MIDTOWN COLLECTION AT HANNAH RIDGE FILING NO. 2

MIDTOWN COLLECTION AT HANNAH RIDGE FILING NO. 2 JOB NO. 1116.30 JANUARY 15, 2019 SHEET 1 OF 3

NO.	REVISION	DATE
1	COUNTY COMMENTS	5-20-19
2

MIDTOWN COLLECTION AT HANNAH RIDGE FILING NO. 2
JOB NO. 1116.30
JANUARY 15, 2019
SHEET 1 OF 3

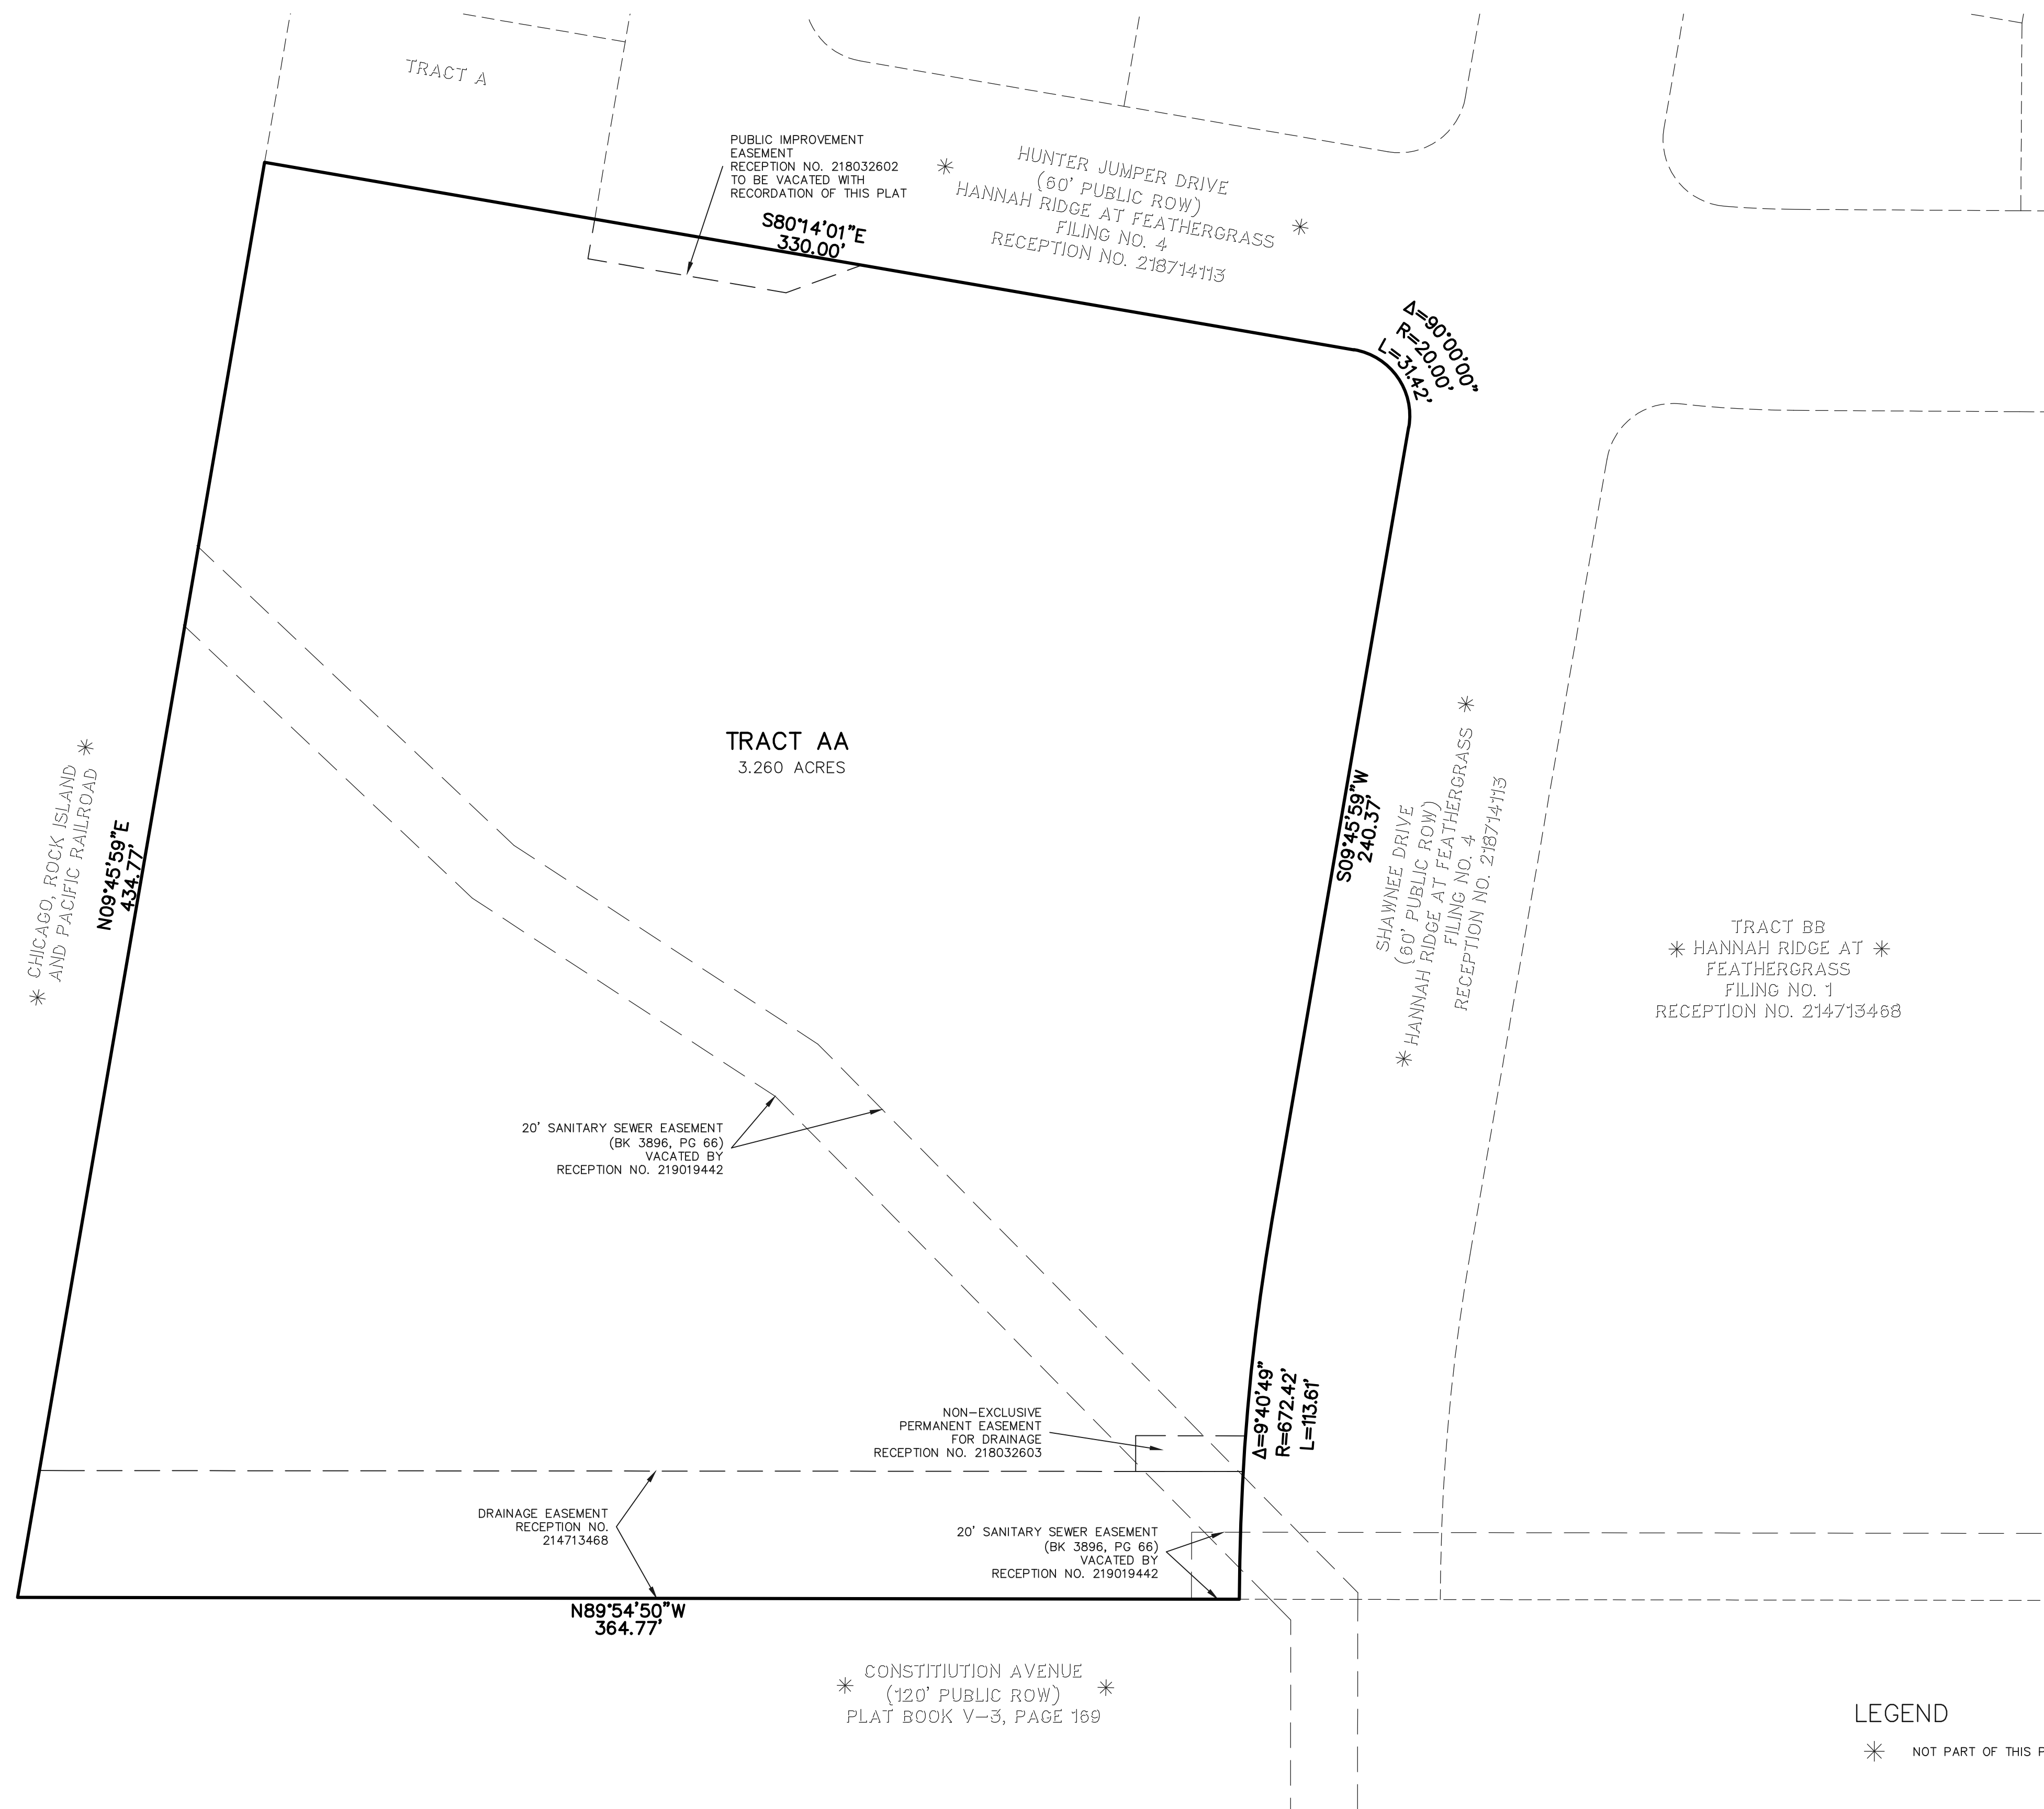
Please follow up with Lori and submit PID inclusion

Noise wall should be identified by note and installation and maintenance of that noise wall
